From: Tyler <Tyler@dotens.com>
To: <buildinginspections@portlandmaine.gov>
Date: 6/25/2015 10:48 AM
Subject: University of Southern Maine Abromson Center
Attachments: SKC 10.1 First Floor Plan.pdf; SKC 10.2 First Floor Ceiling Plan.pdf; Abromson Amended Permit.pdf

Attached is an amended permit and revised plans for the already issued permit 2015-01292.

SKC10.1

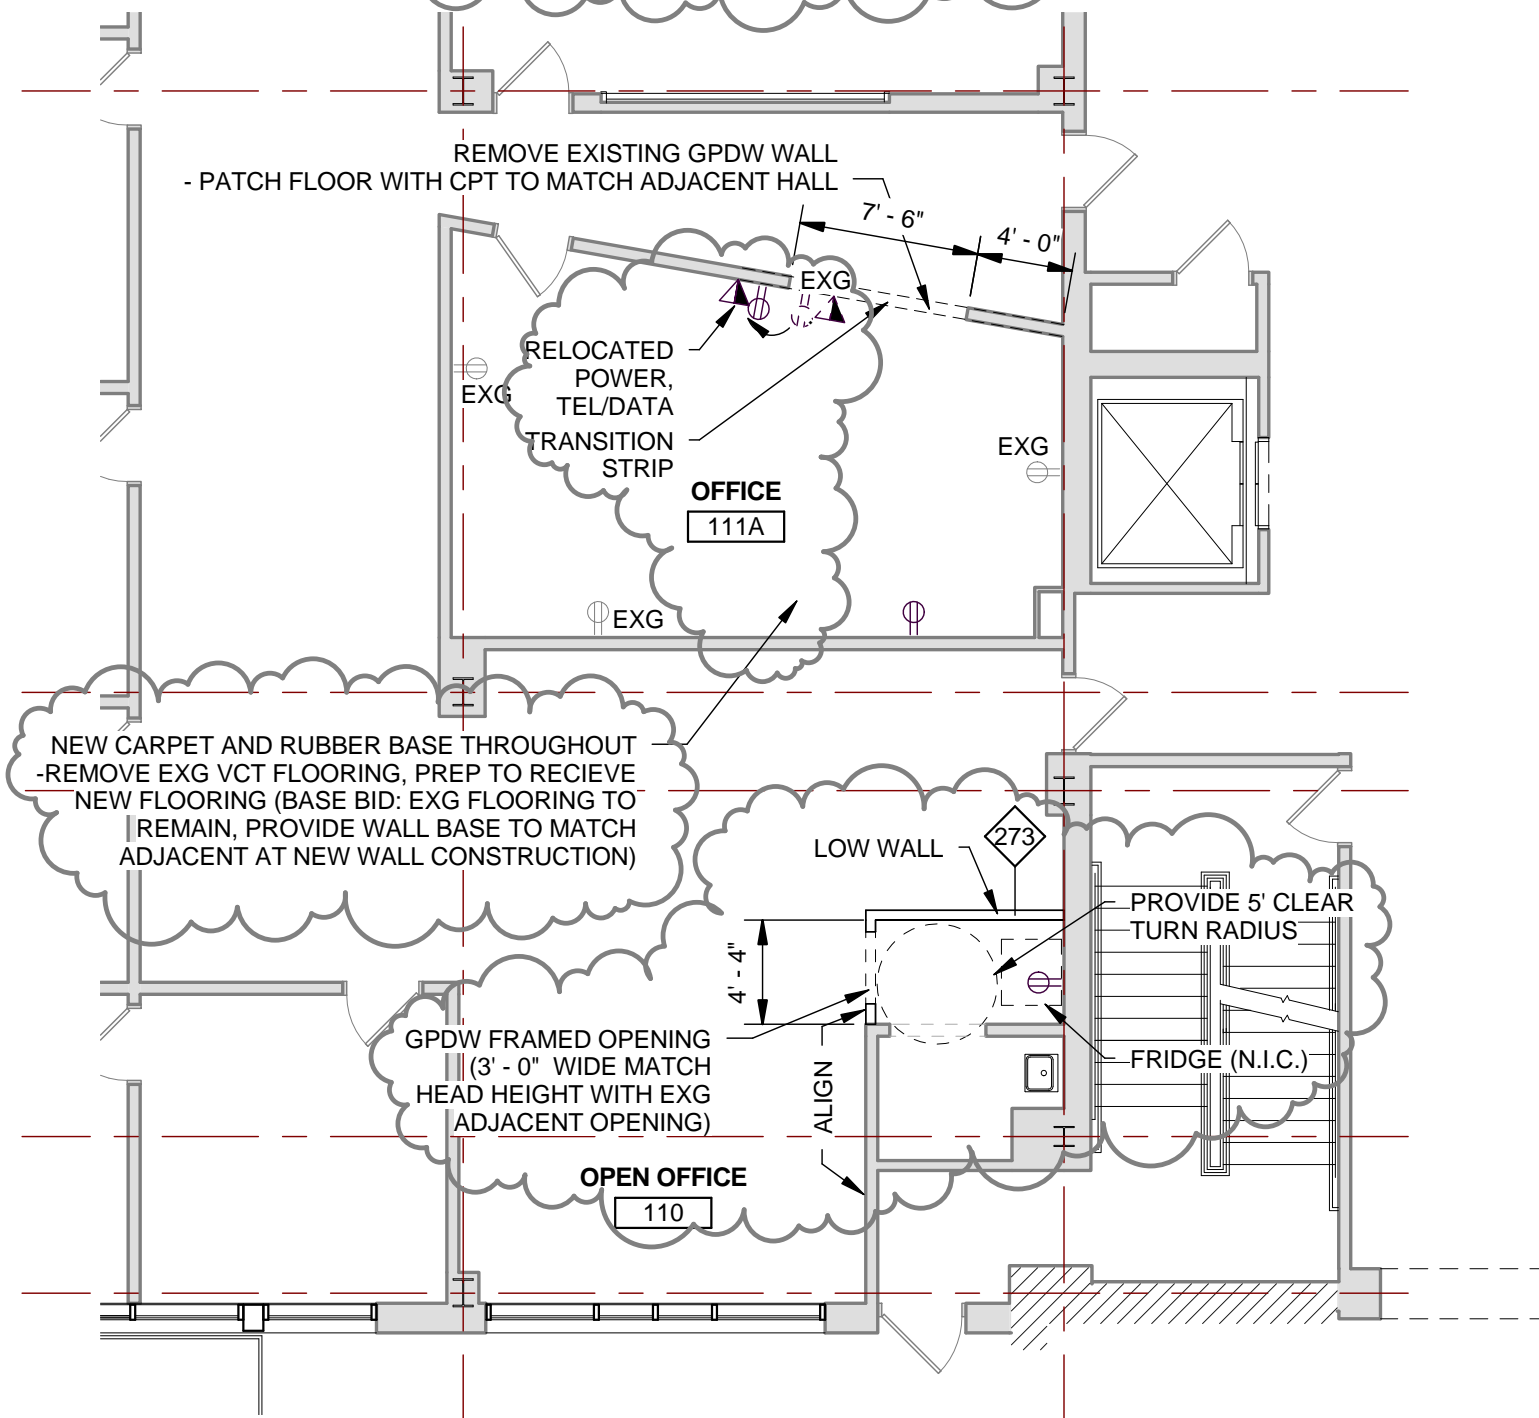
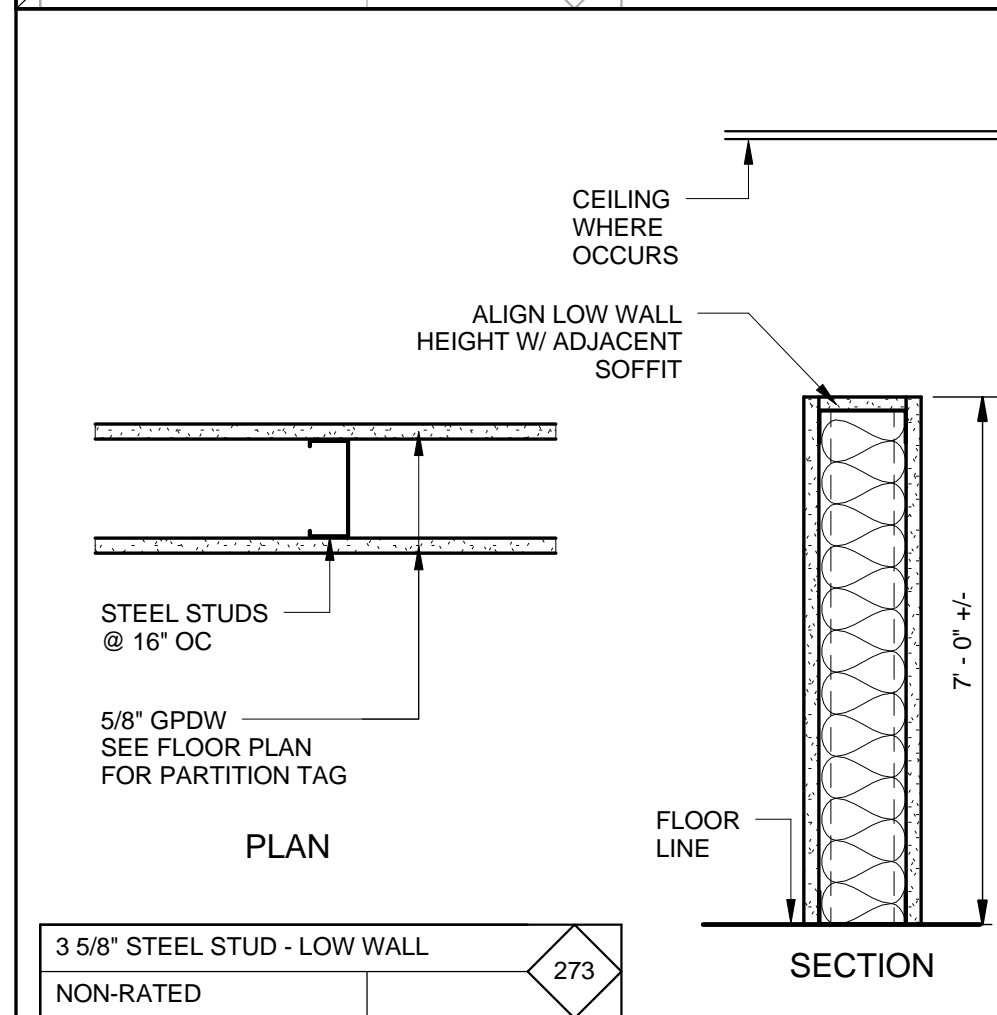
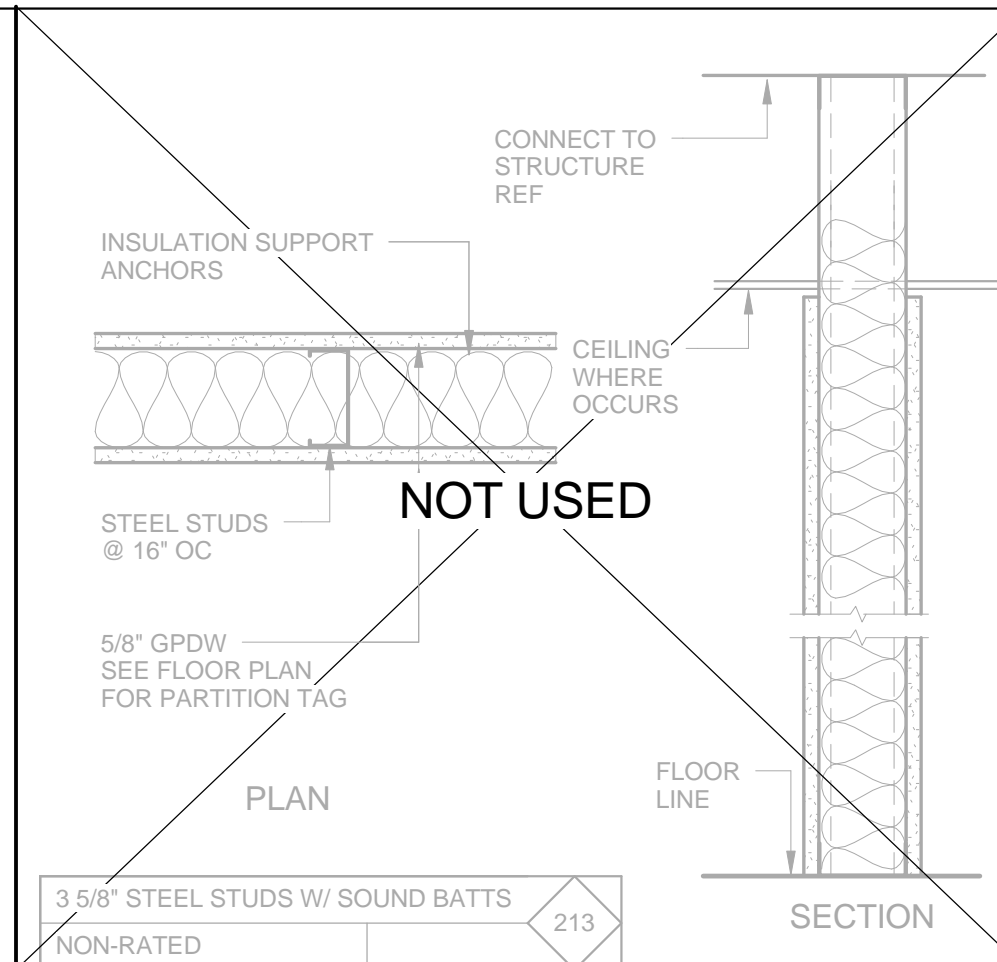
- Office 111A no longer has new interior divider wall
- Flooring is all the same in Office 111A
- New drywall framed doorway in Open Office 110
- New low wall around fridge in Open Office 110
